From: Sue Howell
Sent: 20 June 2017 09:56
To: Planning.Responses
Cc: Simon Davis
Subject: RE: Planning Consultation on: EG/21/17/PL

Comment form Greenspace

NOTIFICATION FROM ARUN DISTRICT COUNCIL
Town & Country Planning Act 1990 (as amended)
Town and Country Planning (Development Management Procedure)
(England) Order 2015
Planning Permission
APPLICATION **EG/21/17/PL**
NO:
Registered: 2nd May
2017

Description of Works: Application for Variation of condition No.2
following the grant of planning permission
EG/22/15/PL relating to plans. Resubmission of
EG/3/16/PL

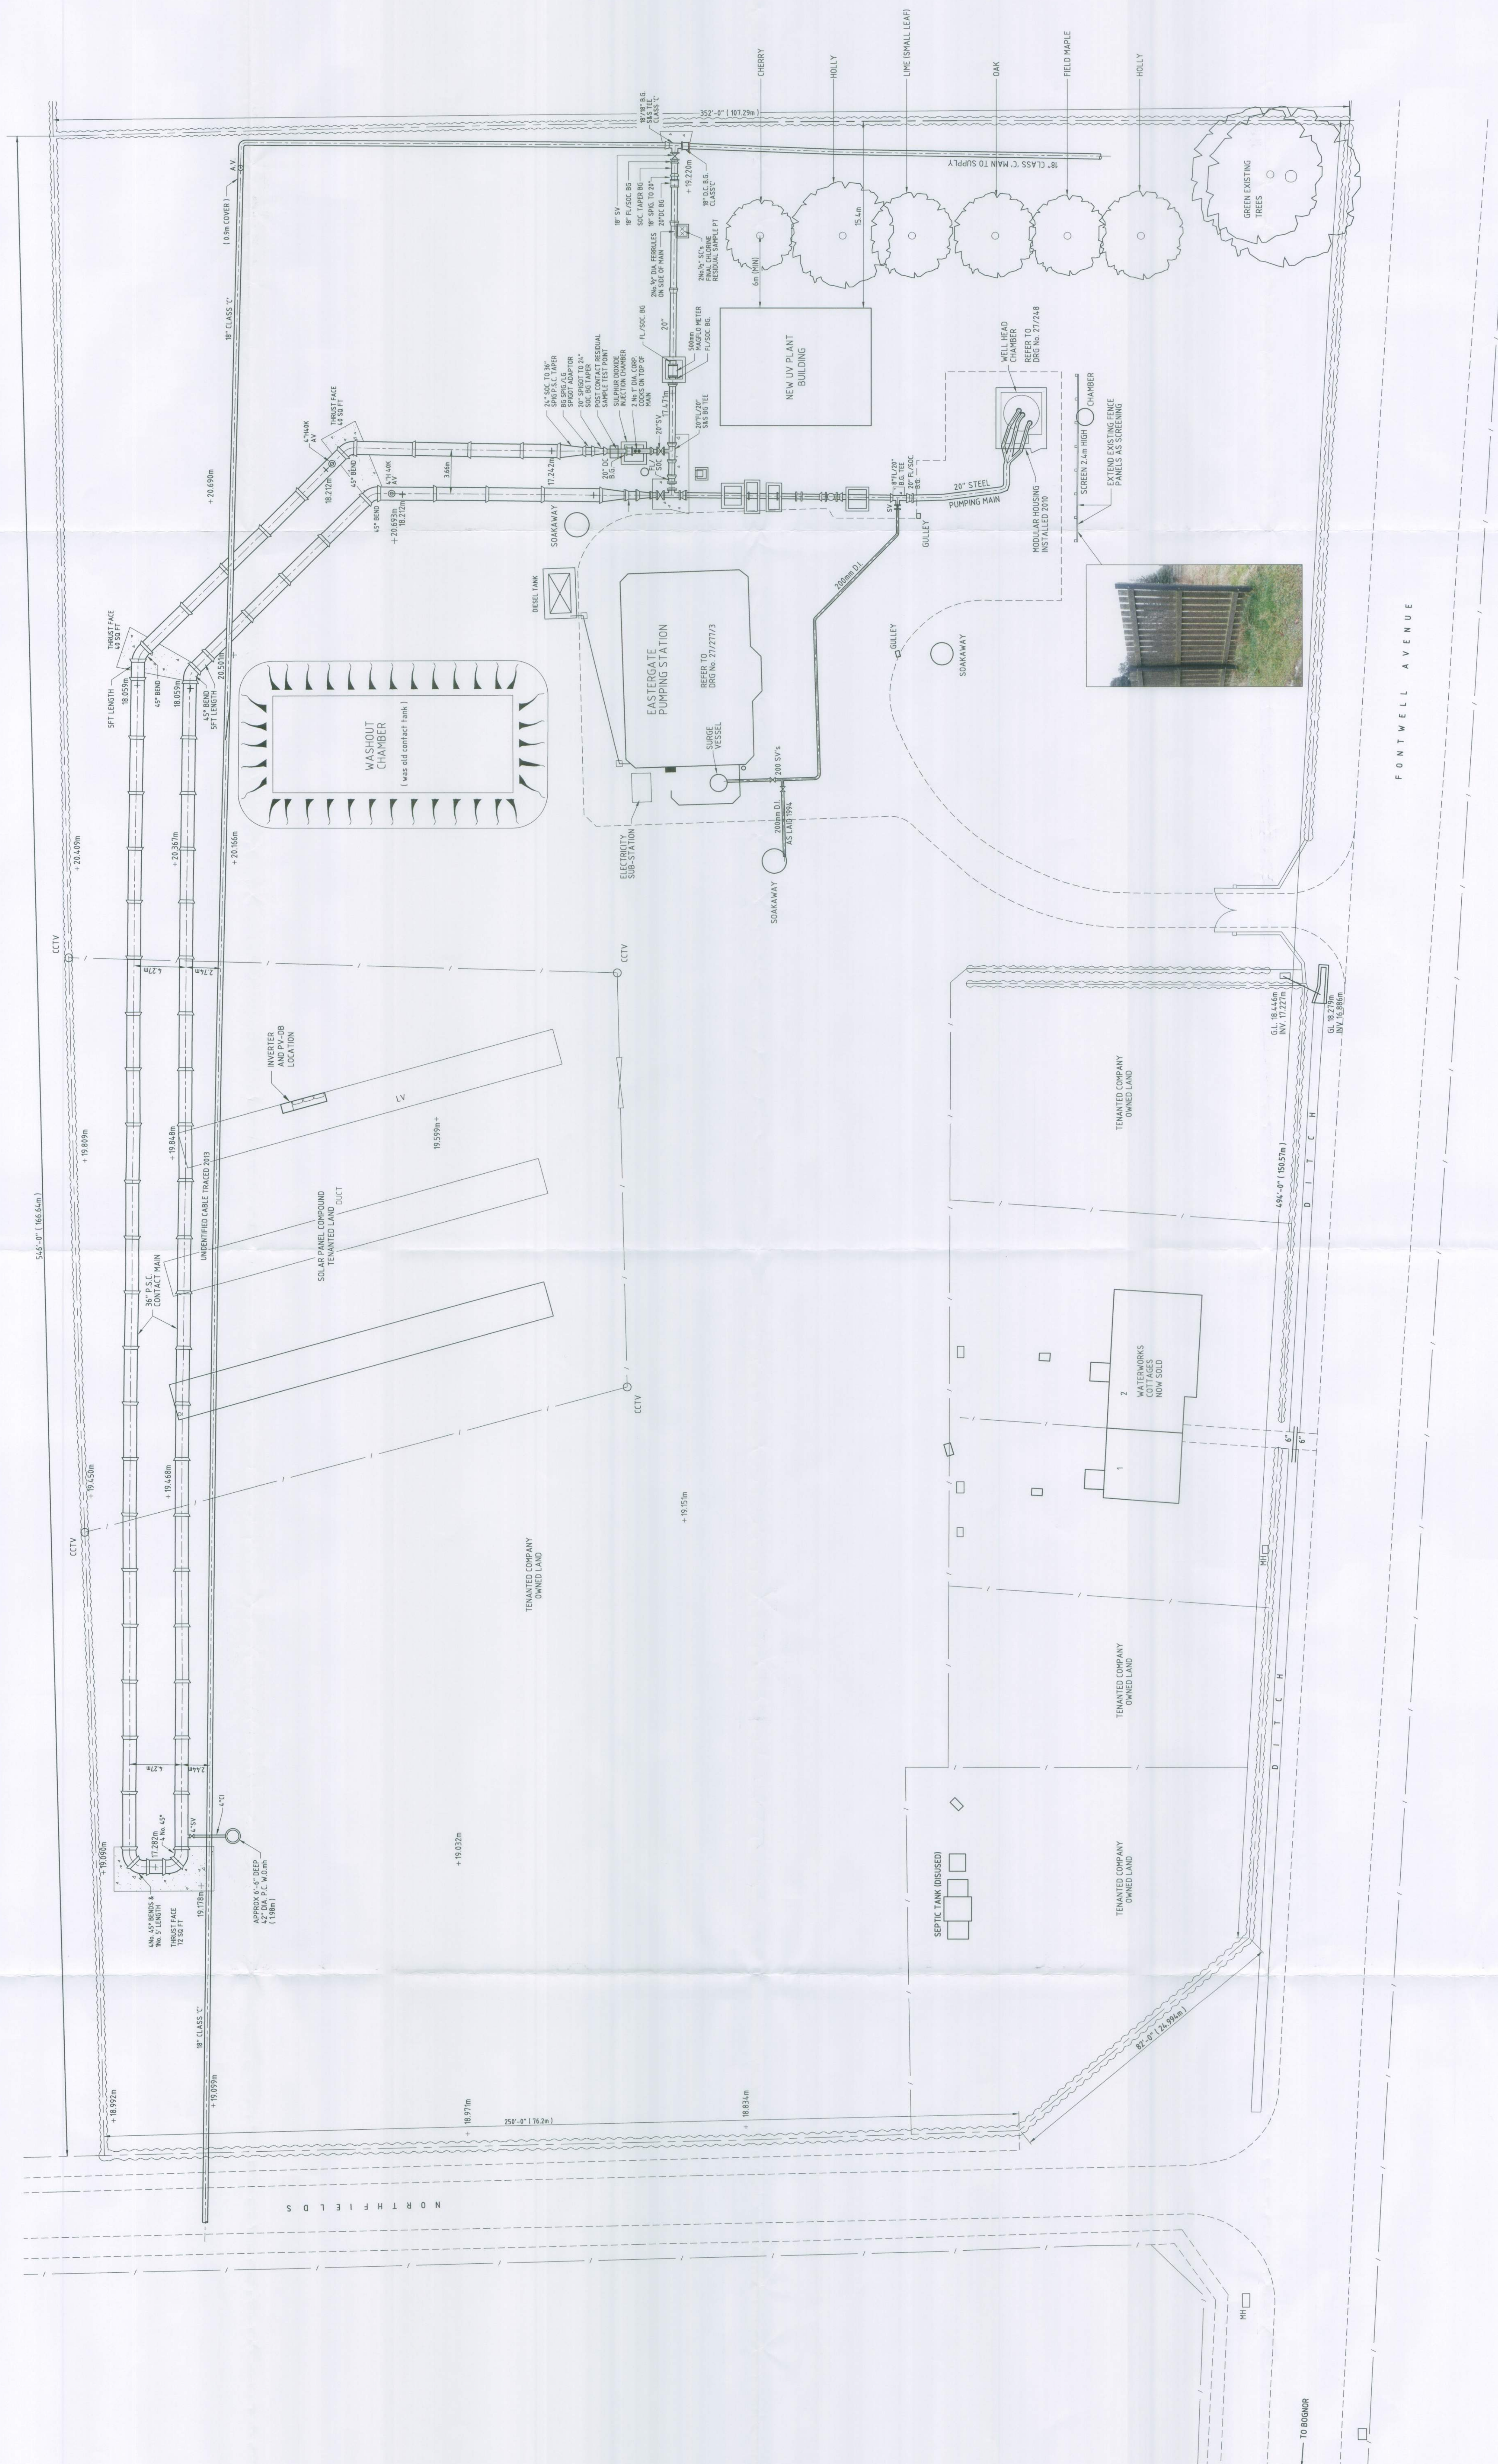
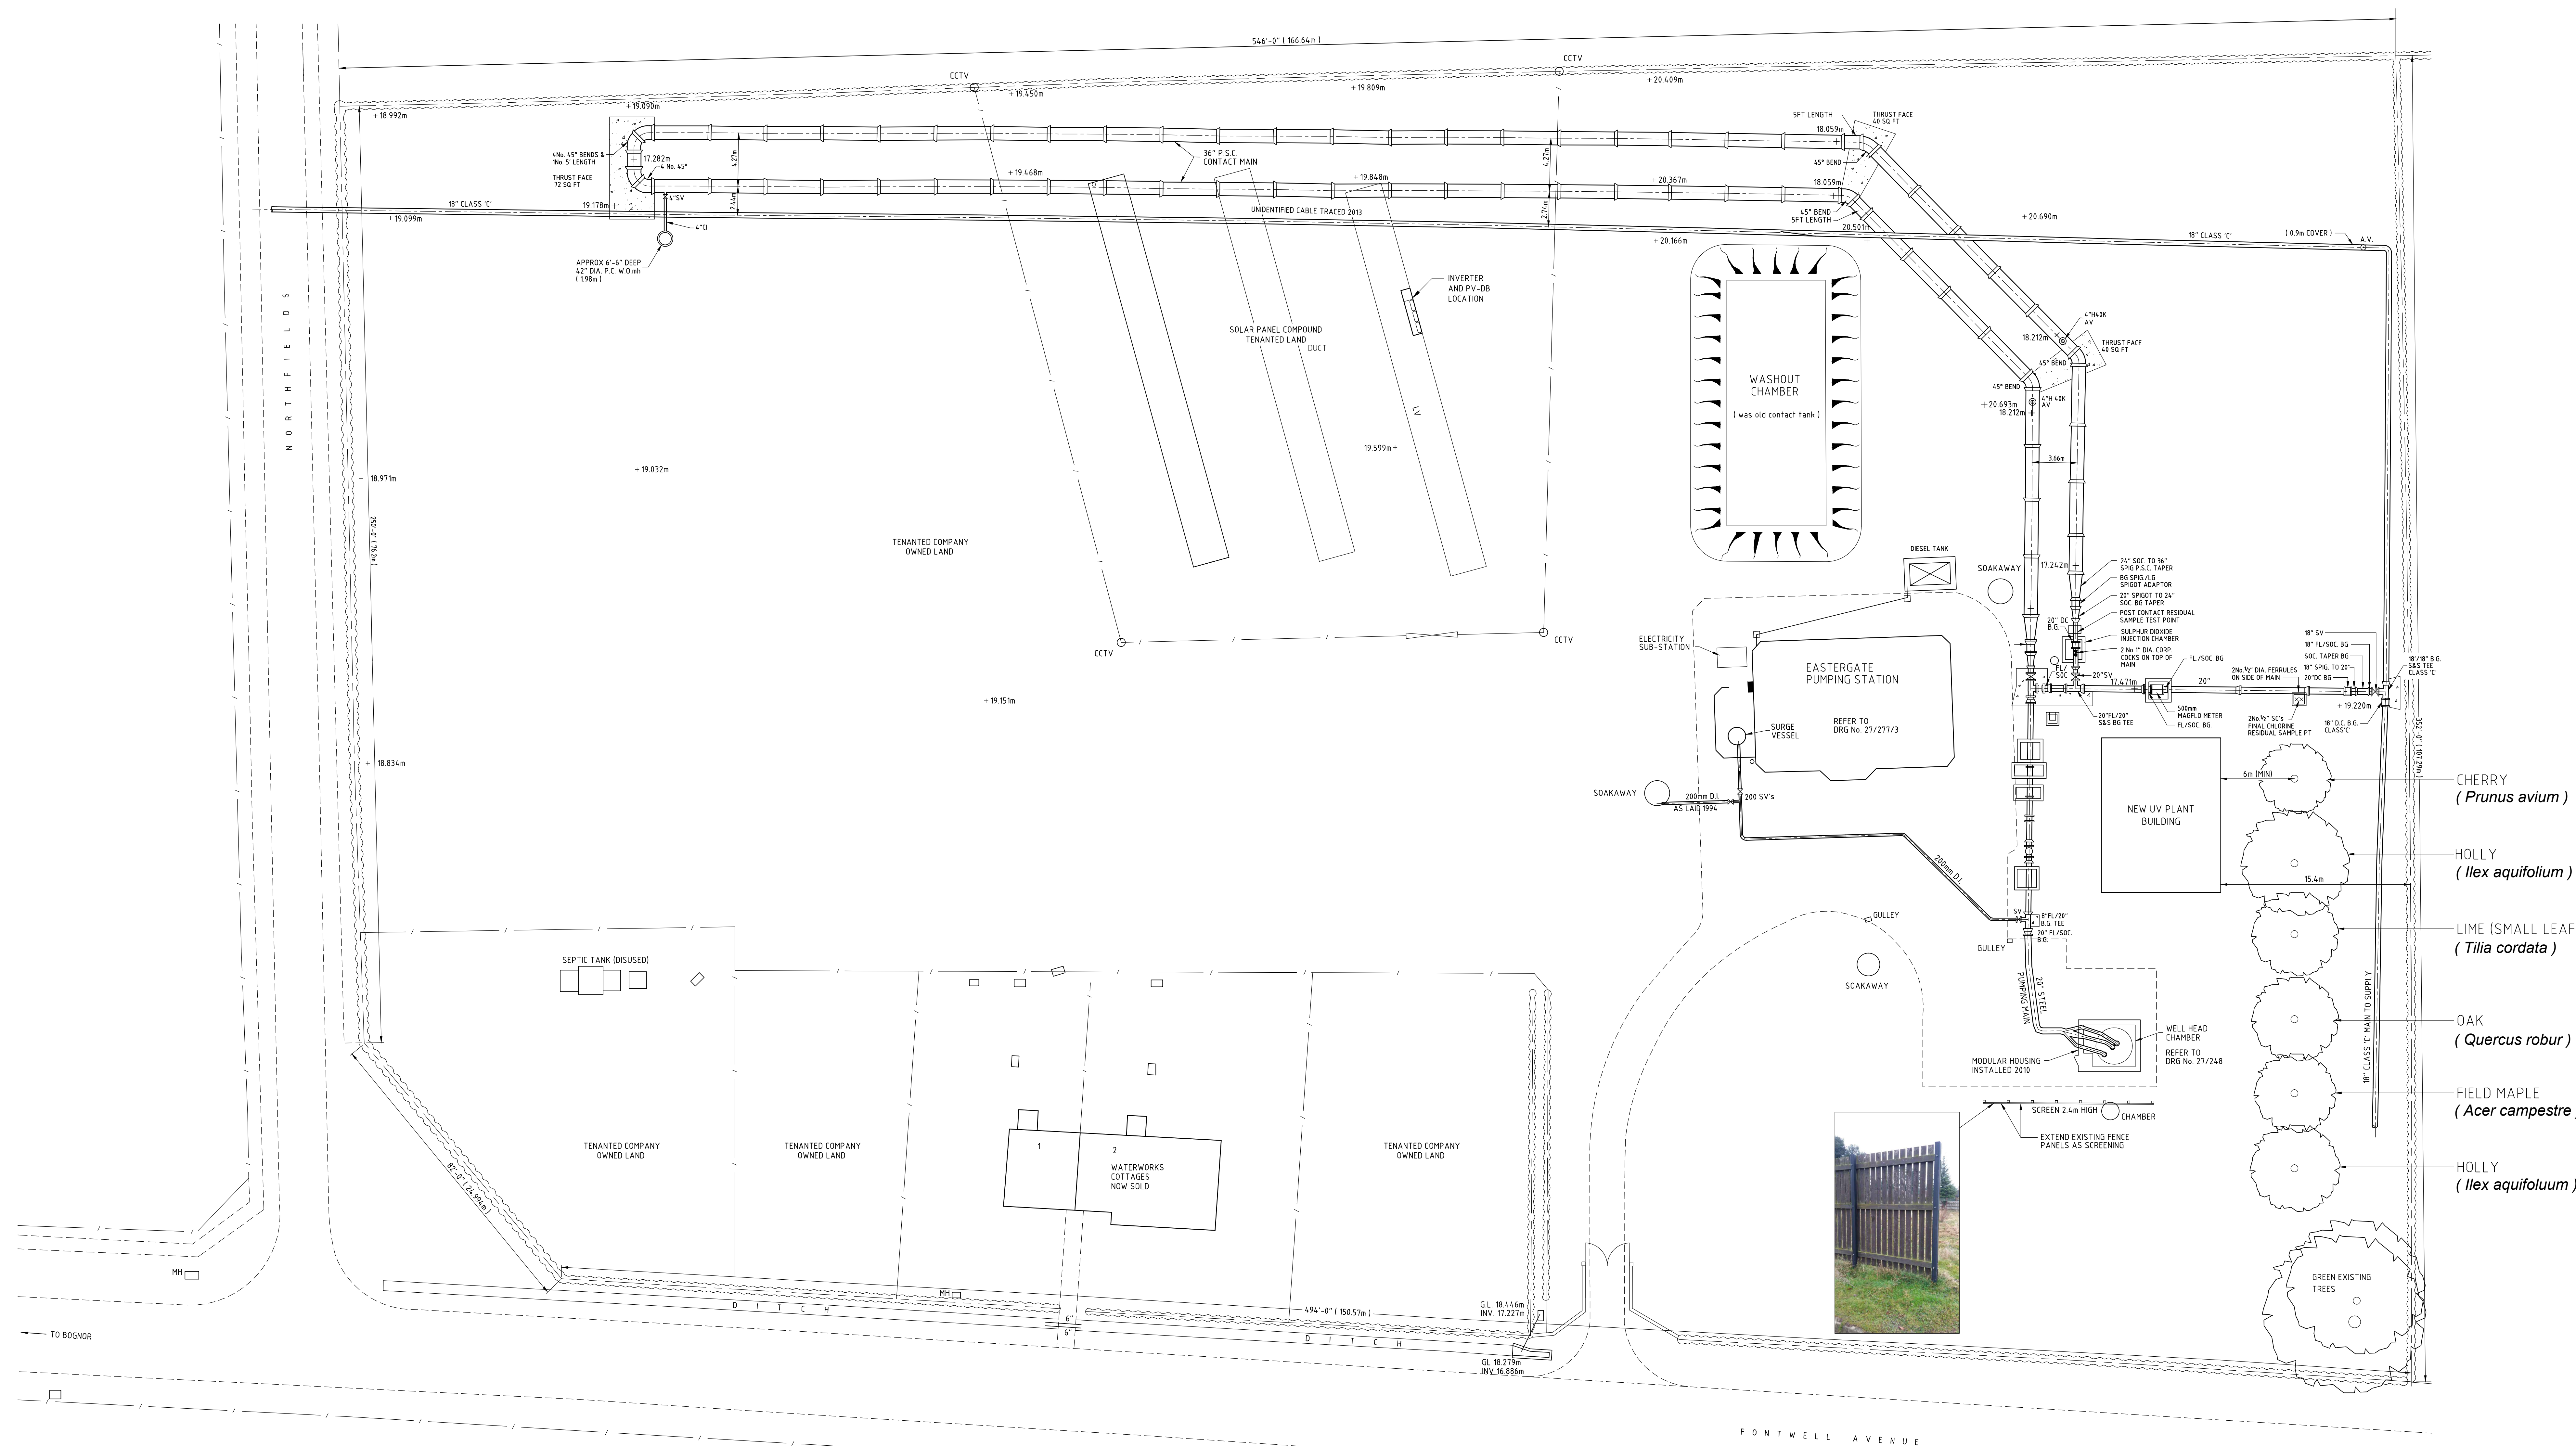
Further to submission of DWG 27/307 landscape detail we advise that the information is still lacking in detail. We require that the screening trees indicated, whilst suitable in species choice need to be detailed in plan form showing (ideally Latin name – so as to be clear of species being proposed) and in addition quantity proposed and the size of these at time of planting. It is assumed that as they are being proposed as screening trees then they should be at least as standards or feathered tree size.

We recommend that this information should be submitted for approval.
